Department of Planning and Environment

OUT22/2527

**Yiribana Logistics Estate (SSD-10272349) –  
Updated Plans and Riparian Lands Assessment**

### Detailed advice to DPE Planning & Assessment regarding the Yiribana Logistics Estate (SSD-10272349) – Updated Plans and Riparian Lands Assessment

E2 - ENVIRONMENTAL CONSERVATION

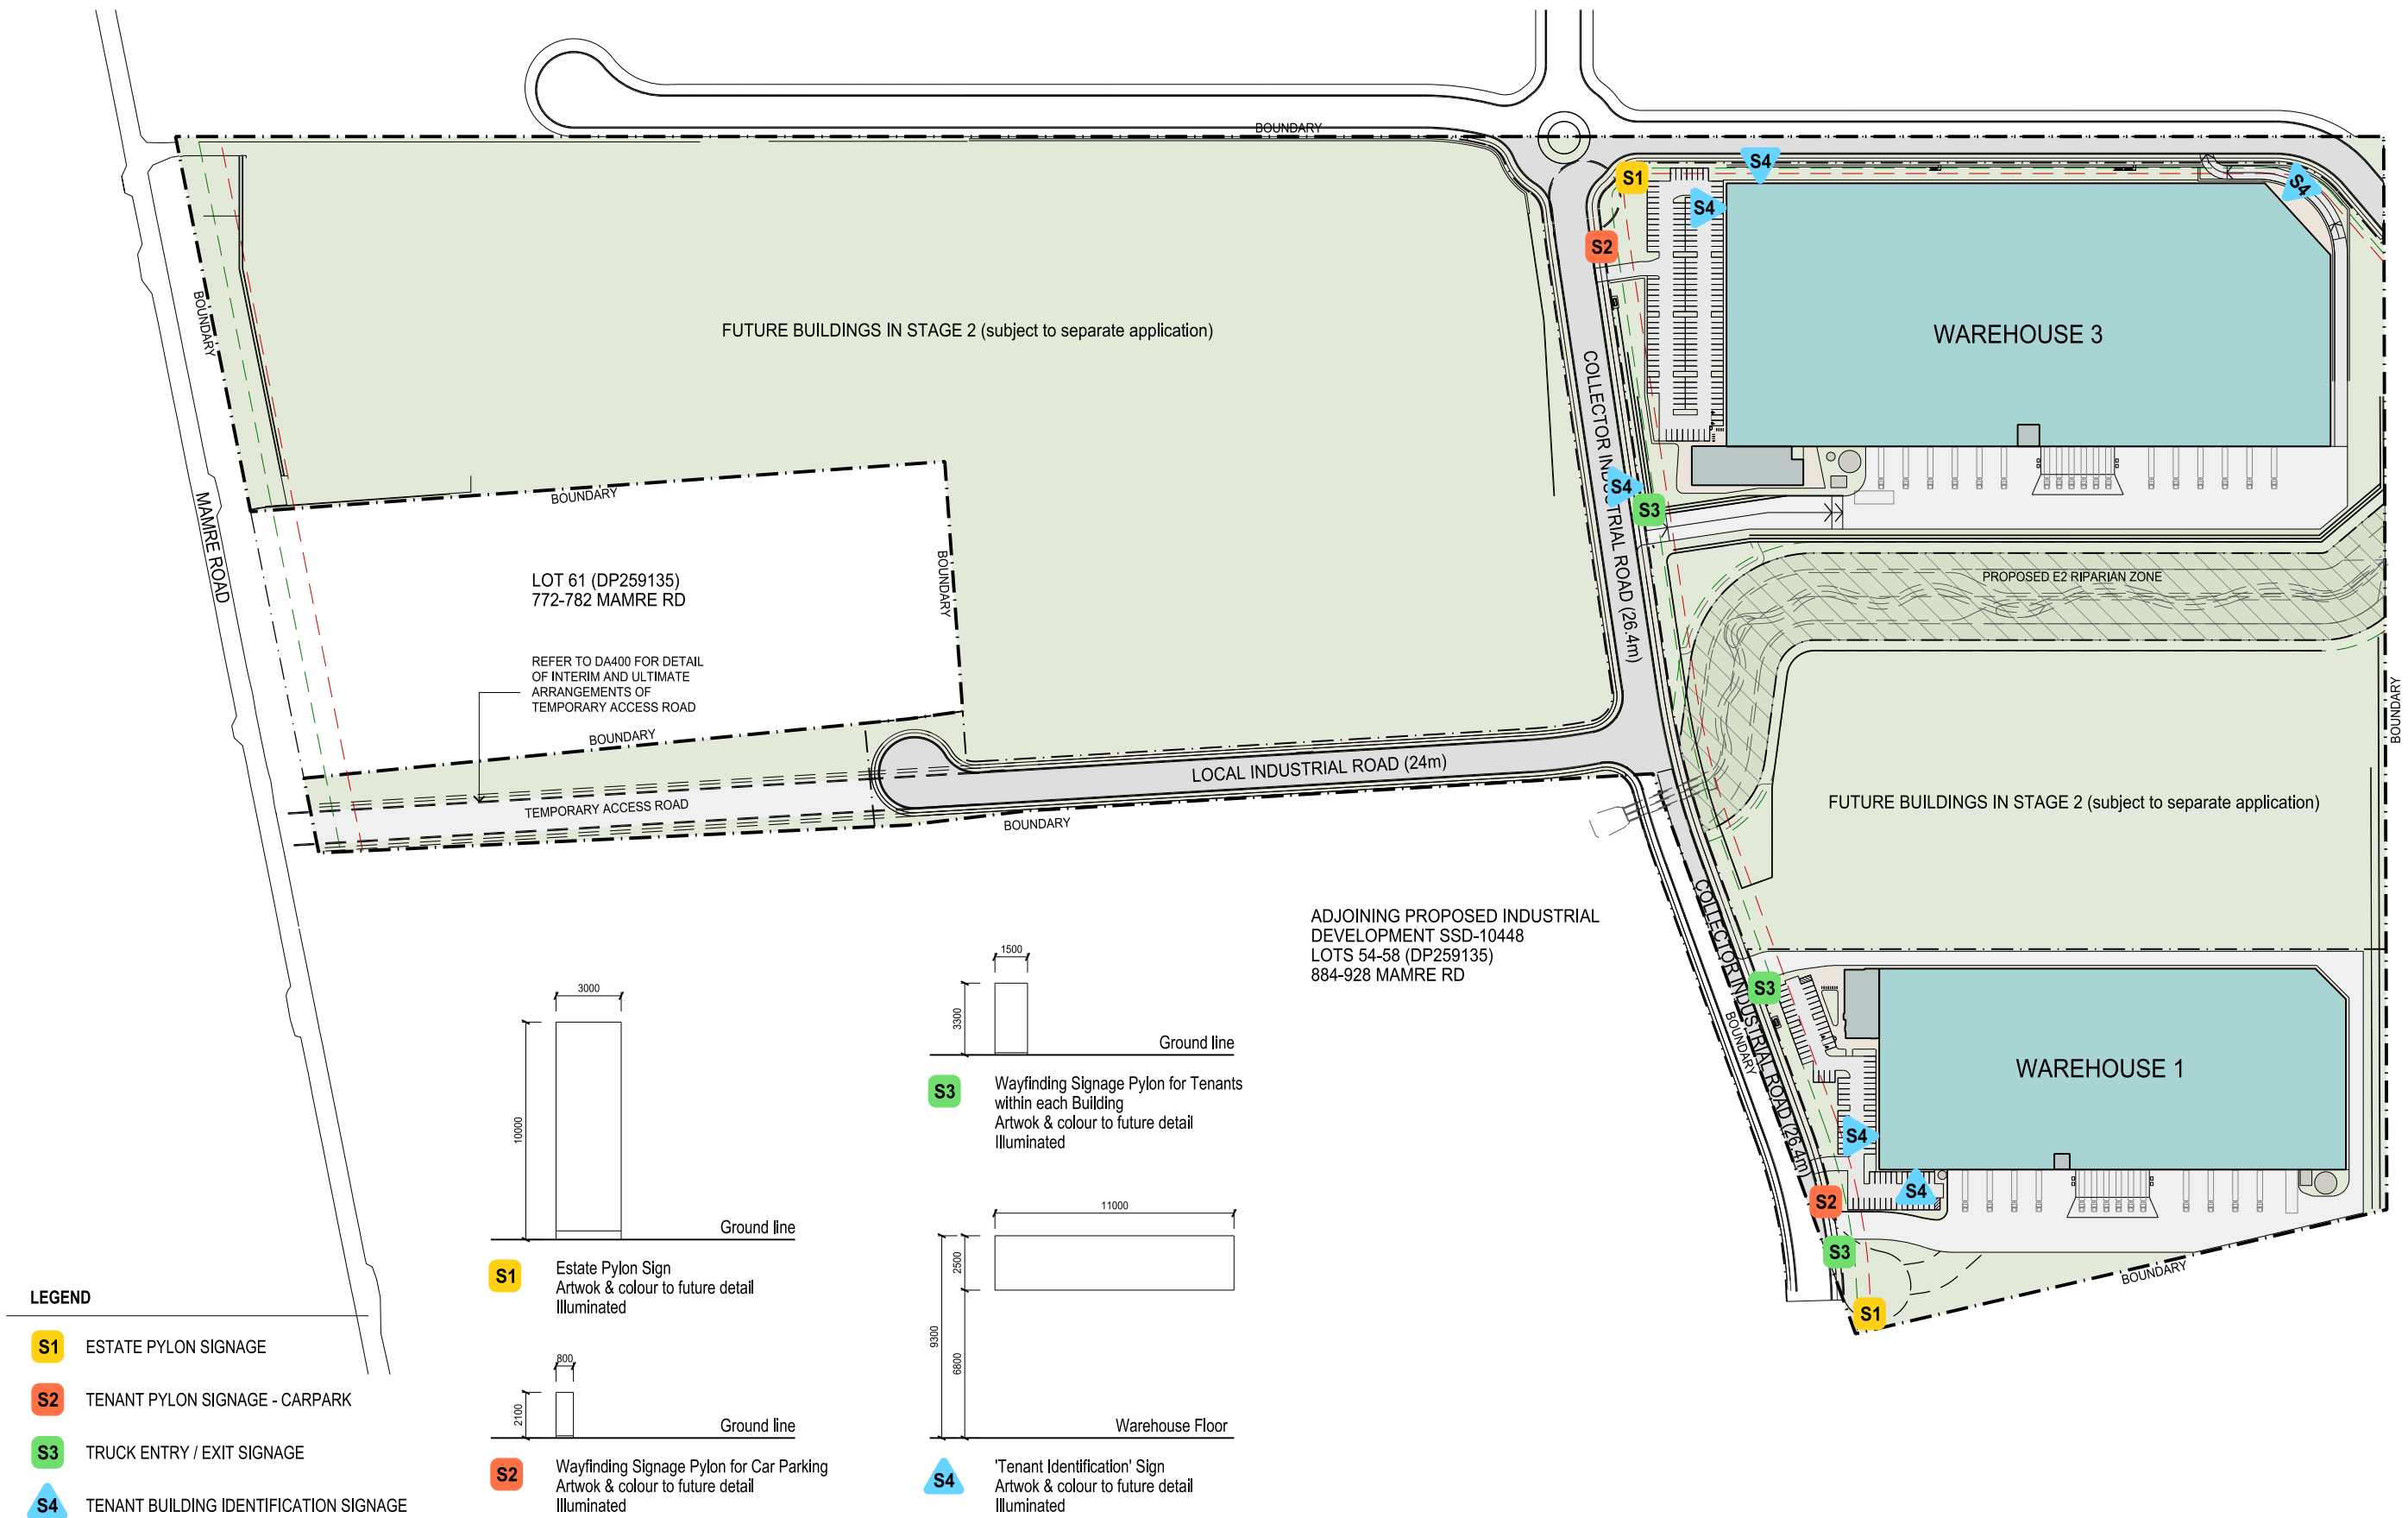
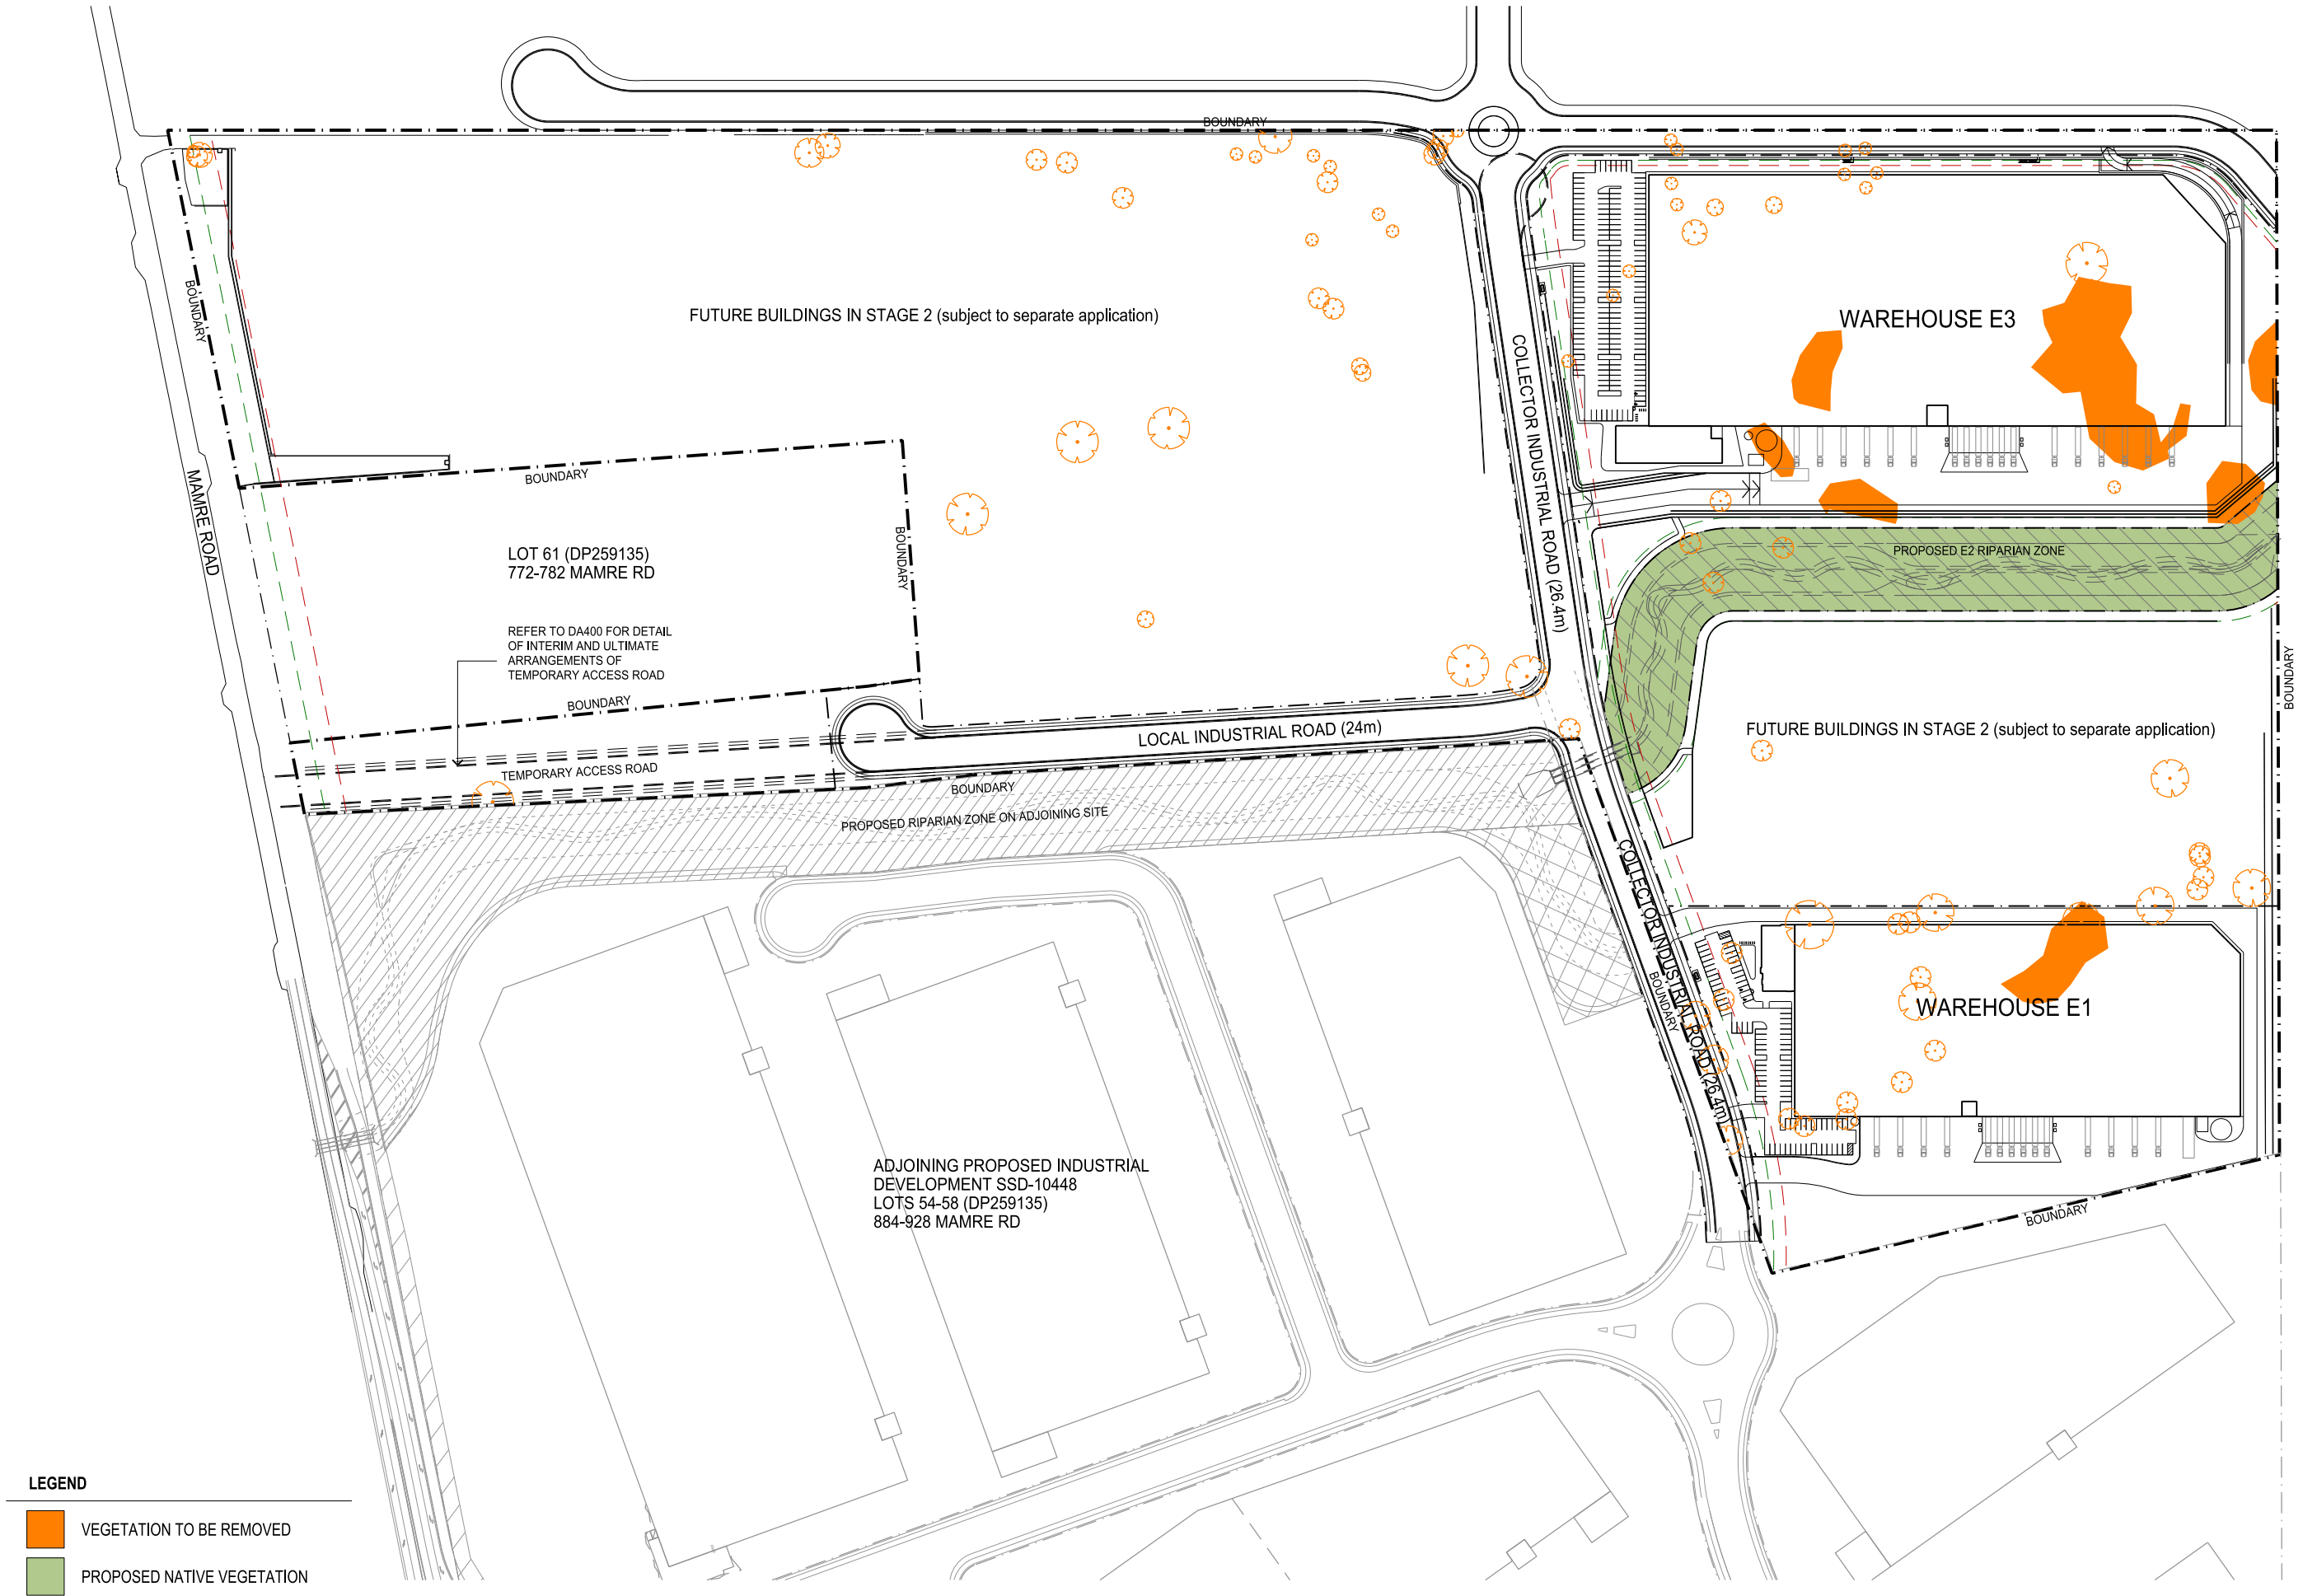
NRAR does not support a reduction in the 40m minimum width E2 corridor. The averaging rule would not apply to the site the way that is proposed, due to the following reasons:

- The proposal to have a 30m corridor for the majority of the site and one large offset area of 75m is not considered appropriate.

While offsetting can be a valuable tool to allow more flexibility with riparian designs the intention is not to reduce the corridor width in the majority of its extent and provide one large area.

NRAR notes that the averaging rule proposed to be used in this development includes the area within the water detention basins (as described in the Riparian Lands Assessment), and these areas should not be included as part of the Riparian Corridor widths.

- The E2 zoning (as per Mamre Road Precinct Development Control Plan 2020 and the Penrith Local Environmental Plan 2010) generally indicates protection of a current watercourse and riparian area or can be for rehabilitation potential around a flow path. In this case it was likely rehabilitation potential.

A 40m total width riparian area has been provided by both up and downstream sites, and maintaining this approach to this project will ensure consistent outcomes for the riparian corridor.

As previously advised in the EIS response, a 40m wide total width structured vegetated riparian corridor would be accepted as to respect the E2 zoning of the area and match adjacent riparian corridor outcomes. It is recognised that this width is less than the NRAR Guidelines for Controlled Activities which requests 20m each side from top of bank of the watercourse.

A 40m total width riparian area has been provided by both the upstream development site (113-153 Aldington Road - SSD-32722834) and the downstream development (Aspect Industrial Estate - SSD-10448).

NRAR maintains its recommendation of a 40 metre wide total width structured vegetated riparian corridor which respects the E2 zoning of the area and matches adjacent riparian corridor outcomes. More detailed advice is provided in Attachment A.
